**STORM WATER MANAGEMENT PLAN
FOR
FALCON BIG R STORE EXPANSION
EL PASO COUNTY, COLORADO**

December 2021

PCD Project Number: PPR-21-076

**STORM WATER MANAGEMENT PLAN FOR
FALCON BIG R STORE EXPANSION**

**FALCON BIG R STORE EXPANSION**  
14155 E HIGHWAY 24

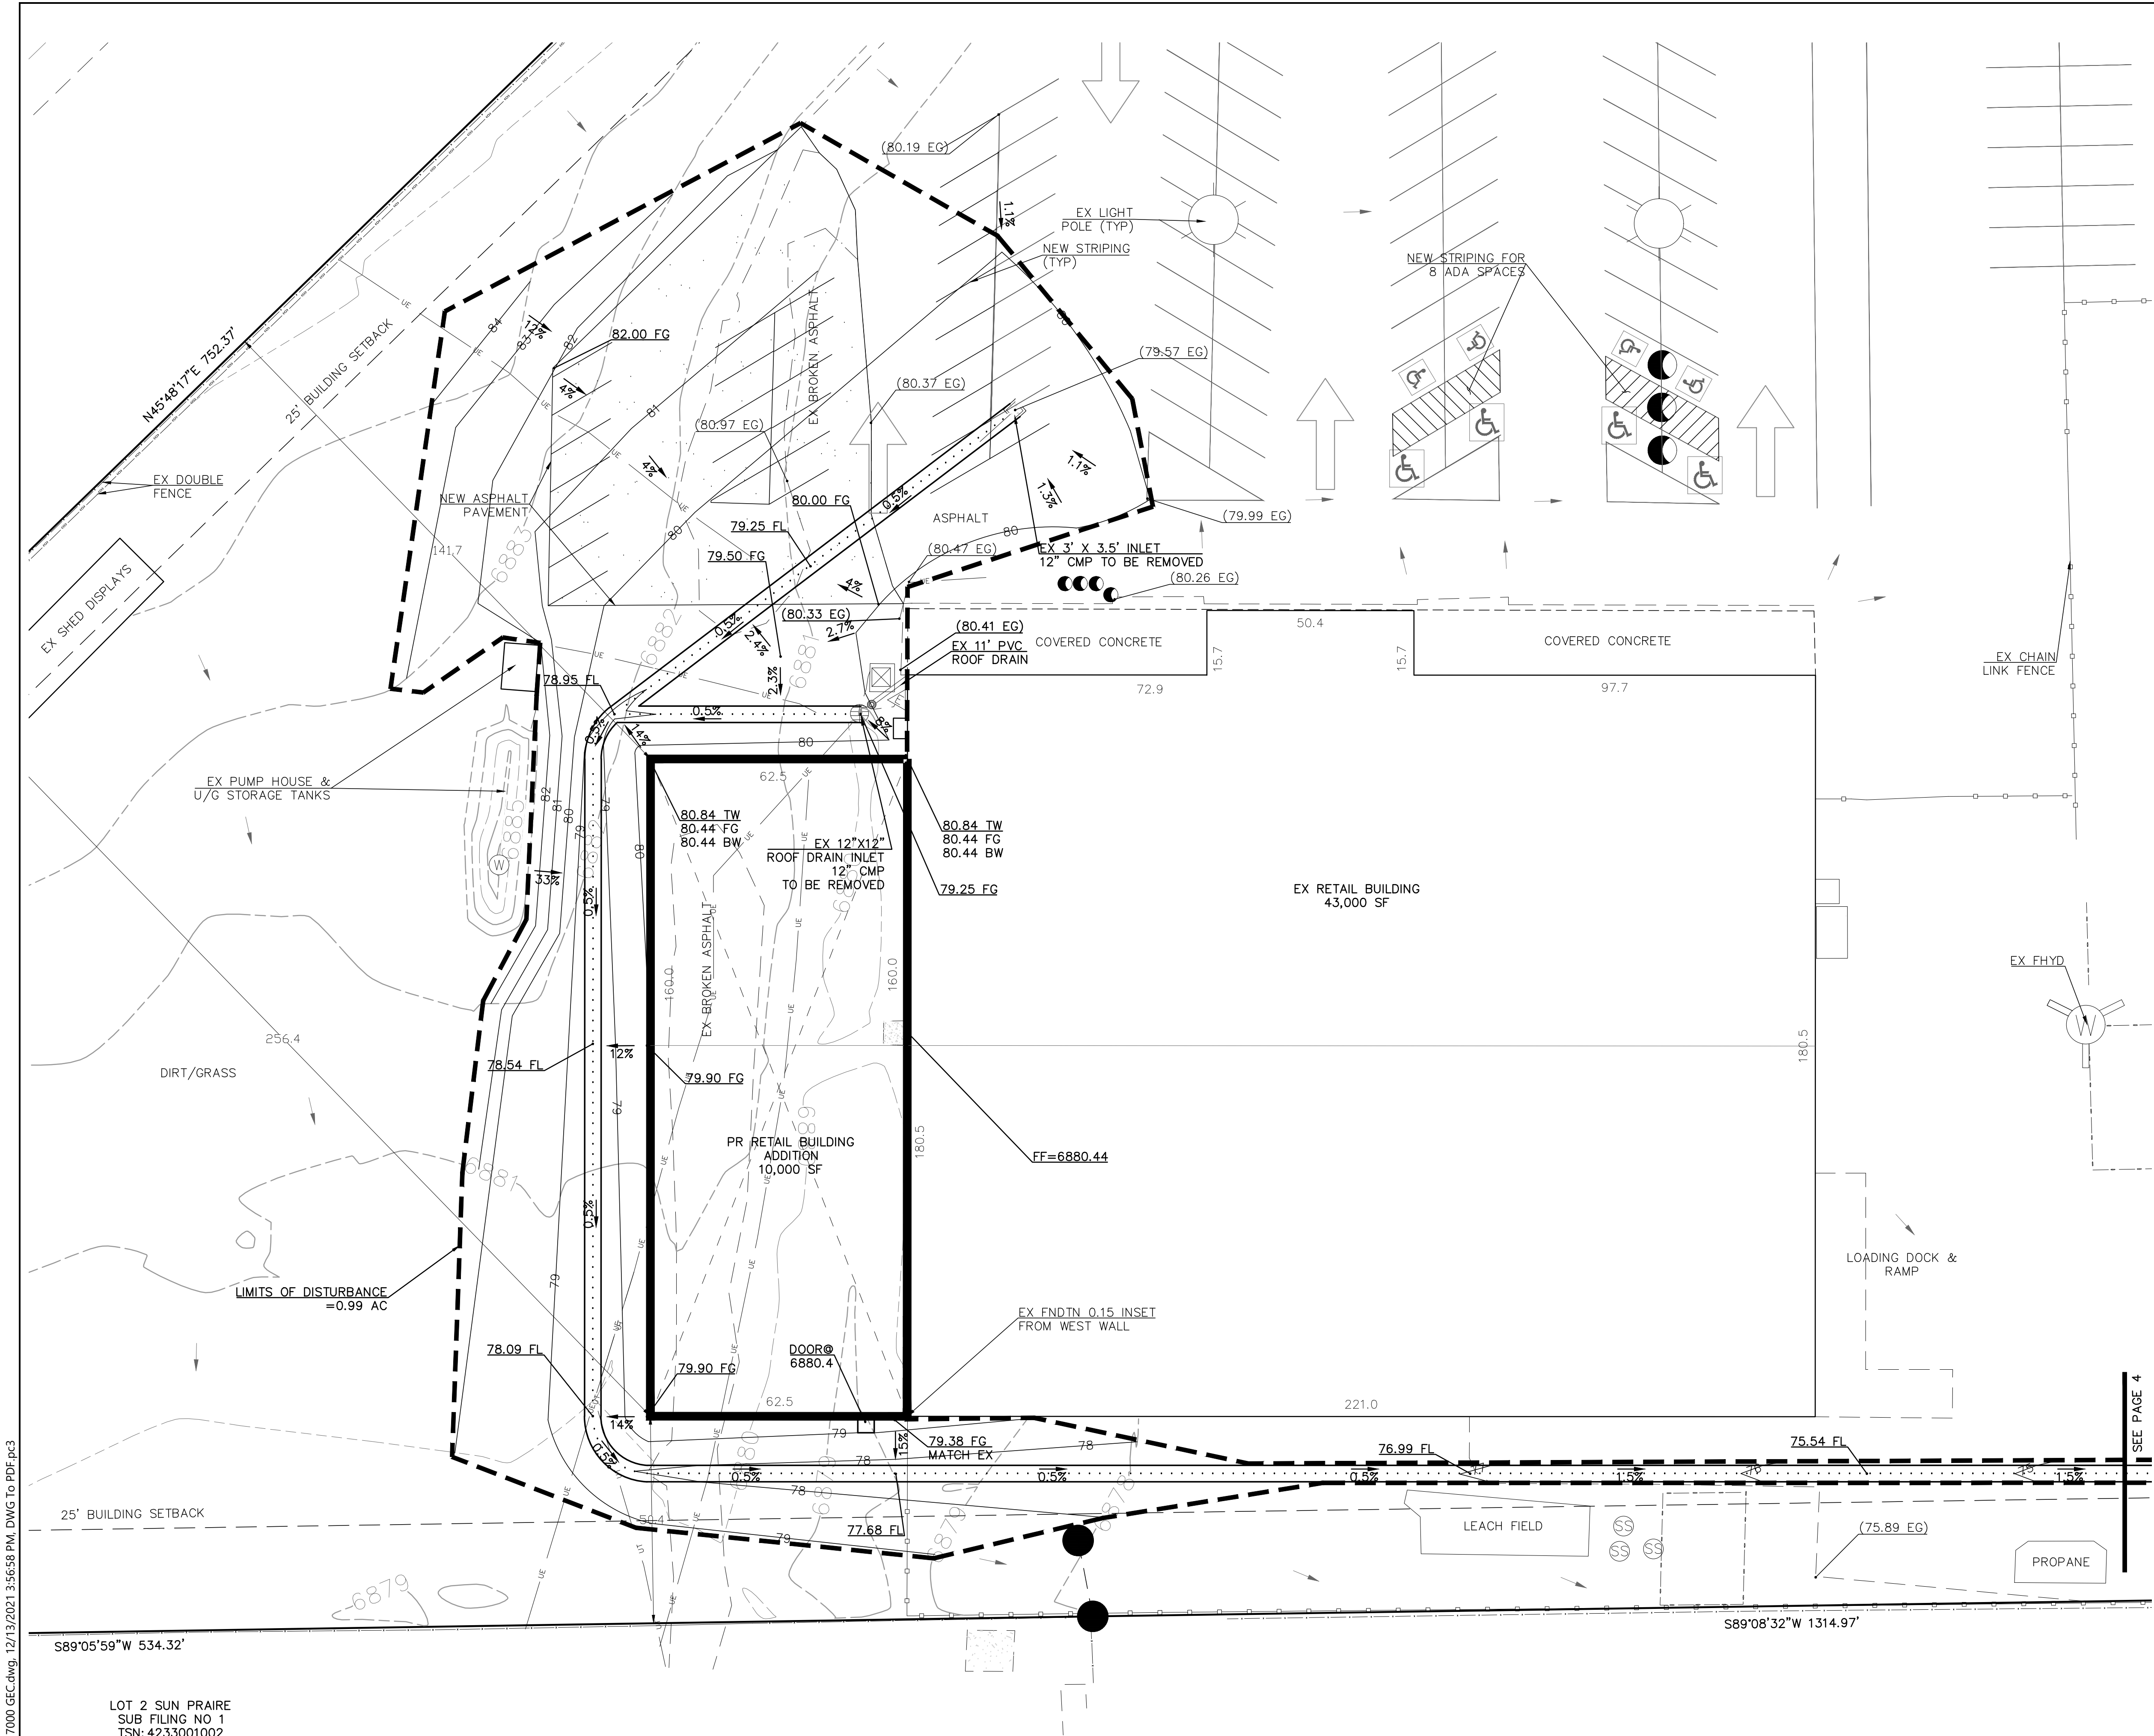
I dont see any construction areas within the floodplain on the GEC

include VTC, construction fencing, temporary sediment basin

discuss concrete washout area
